Letter No. L1/9465/92

Sub: MMDA - Planning Permission - Sub-division of  
Plot m. 8 - at D.M. 1 Diwan Bahadur Shennugan Street  
at W.D.S. No 3177/1 and 3178 of  
Purasavakkam Village, Development Charges  
to be remitted - regarding

**SITE PLAN OF PROPOSED SUB DIVISION IN PLOT No.8,
 DOOR No.1, R.S.No.3177/1 & 3178, MEDAVAKKAM TANK ROAD,
 DIWAN BAHADUR SHANMUGAM STREET, L.A.No.43/1963,
 DIVISION No.57.**

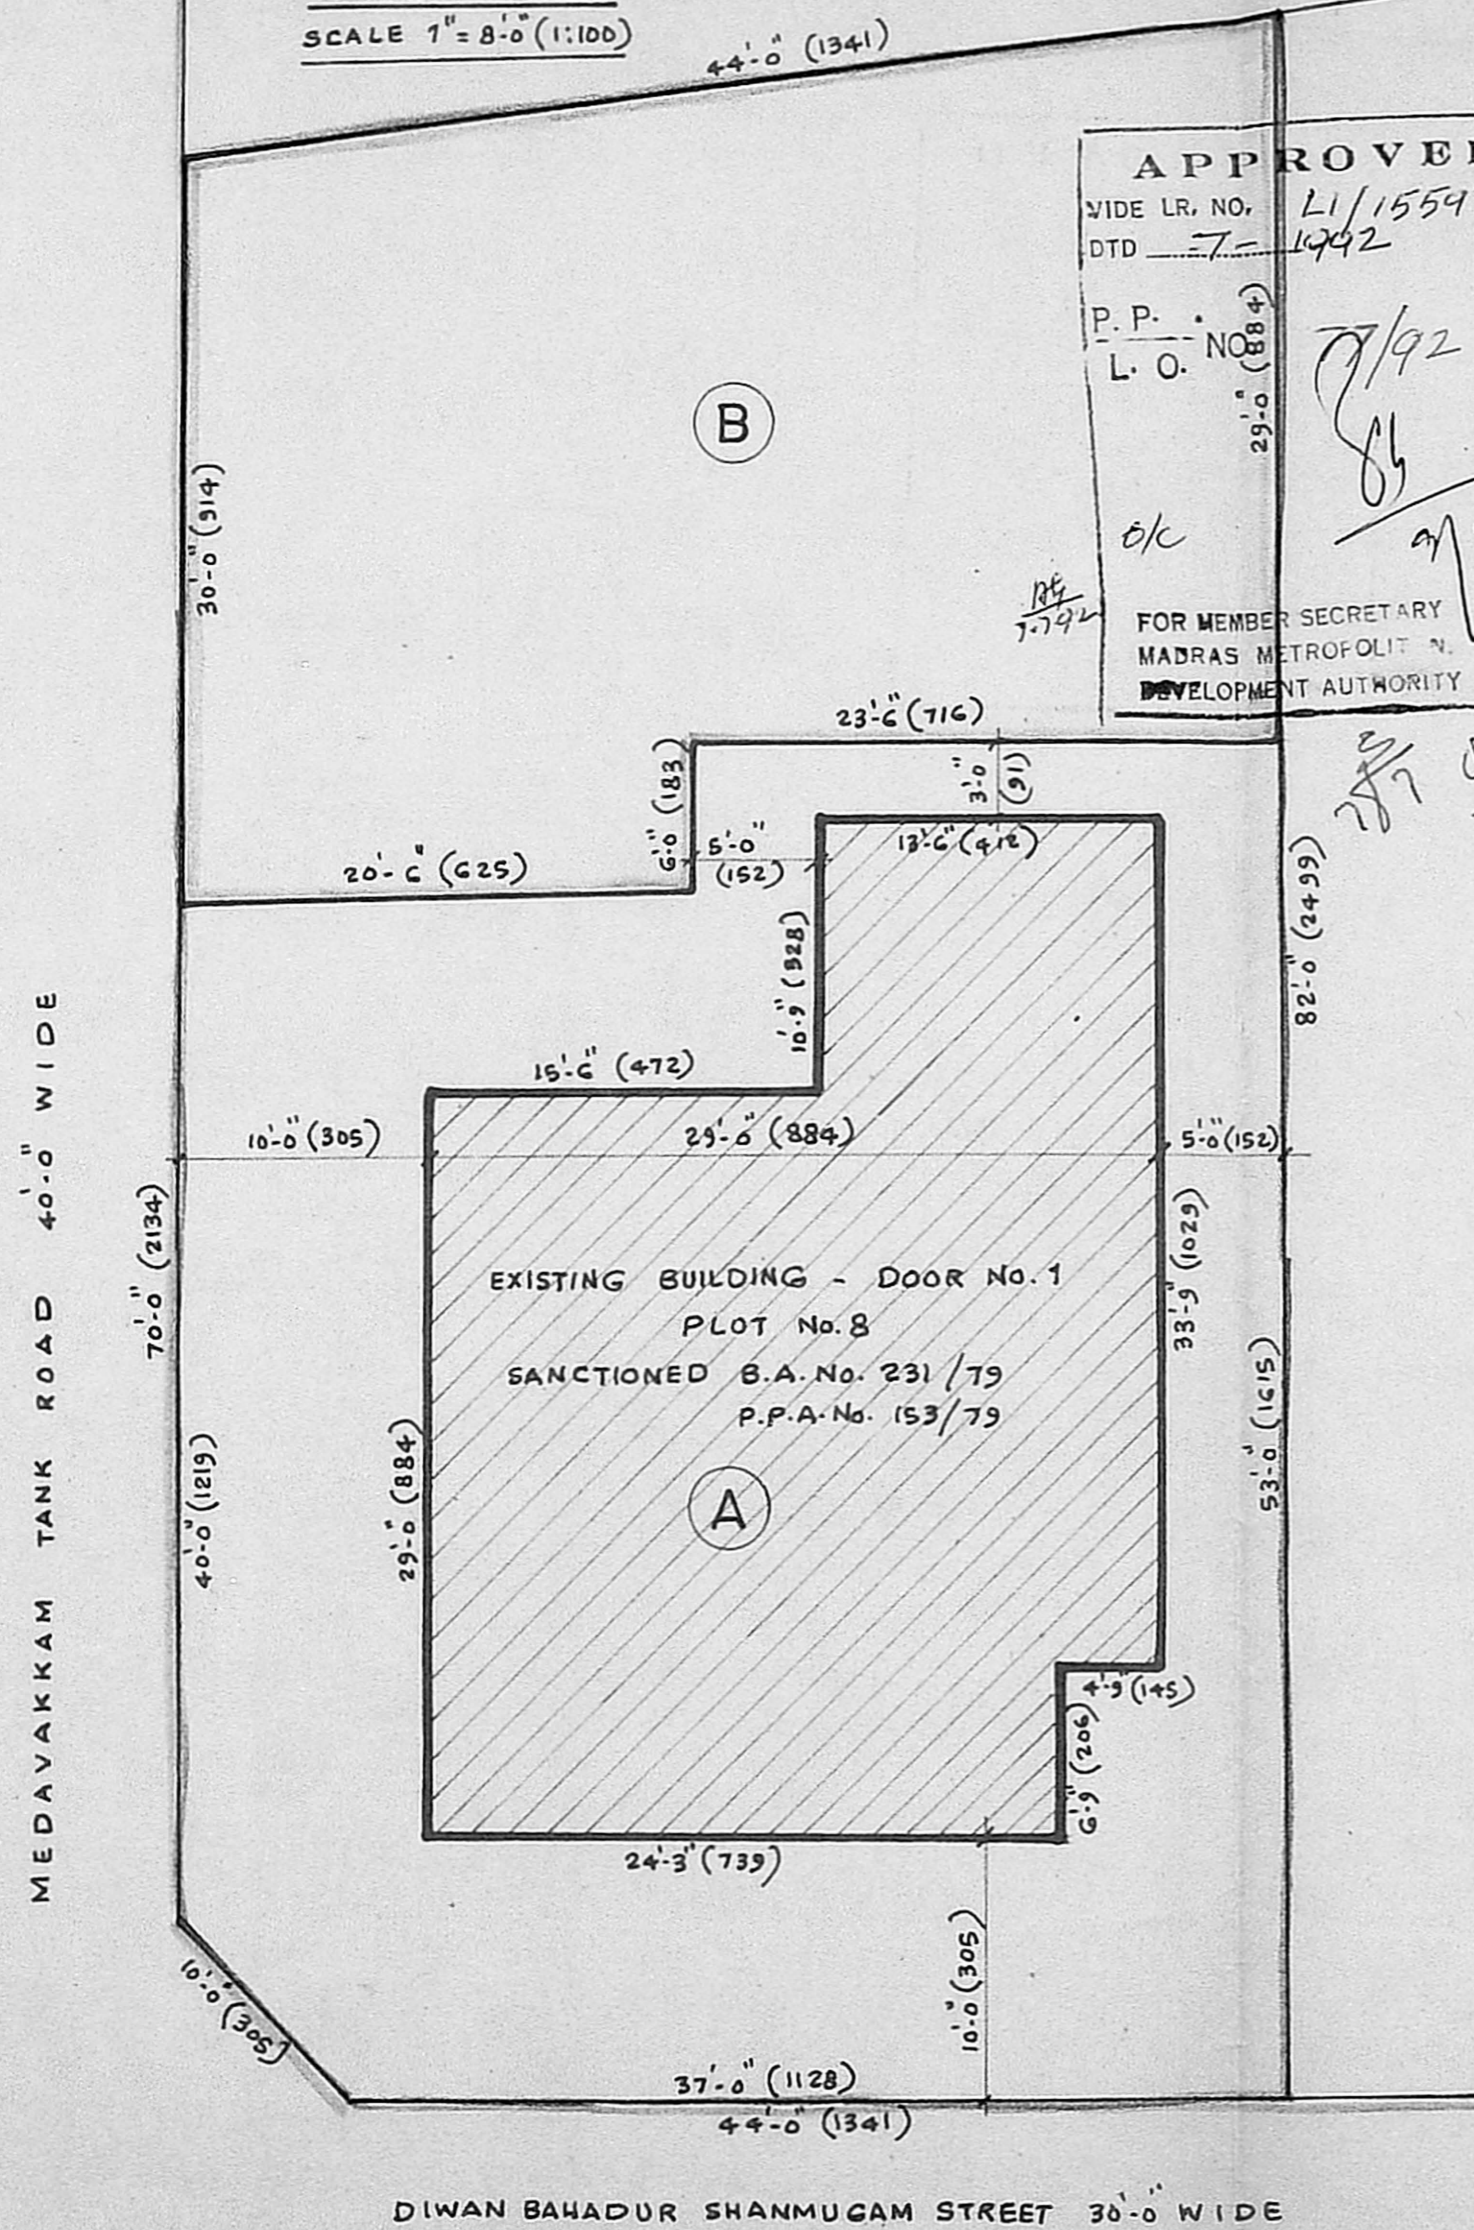
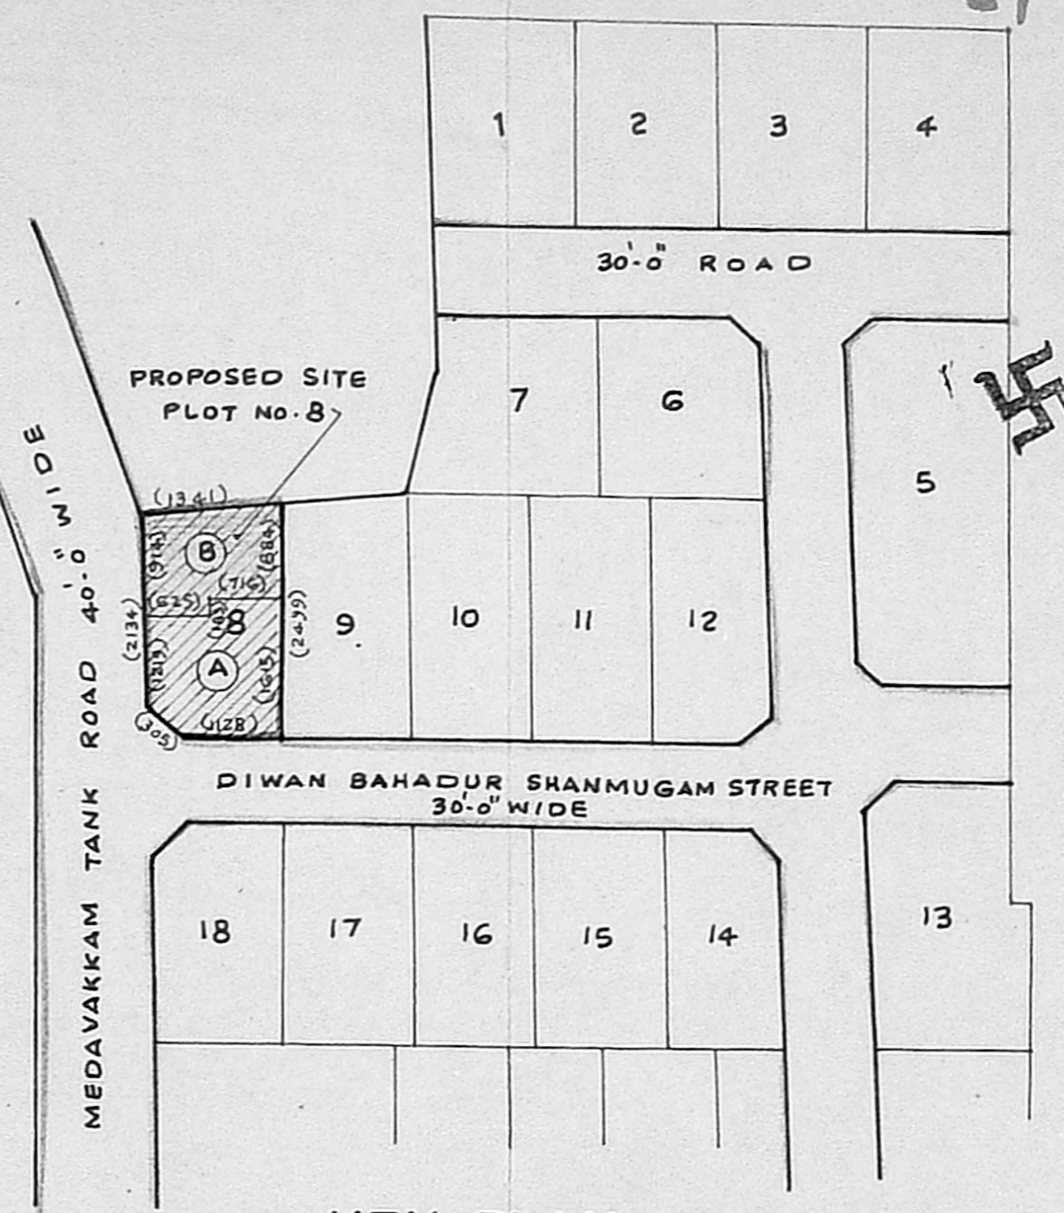
3A) you are requested to submit <sup>the revised sub-division</sup> plans (5 copies) showing the measurement of the <sup>eg. building</sup> and also showing 300' of open space <sup>to the north of the</sup>

*Eg. building that may be available. Show to the sub-division of plot (B)*
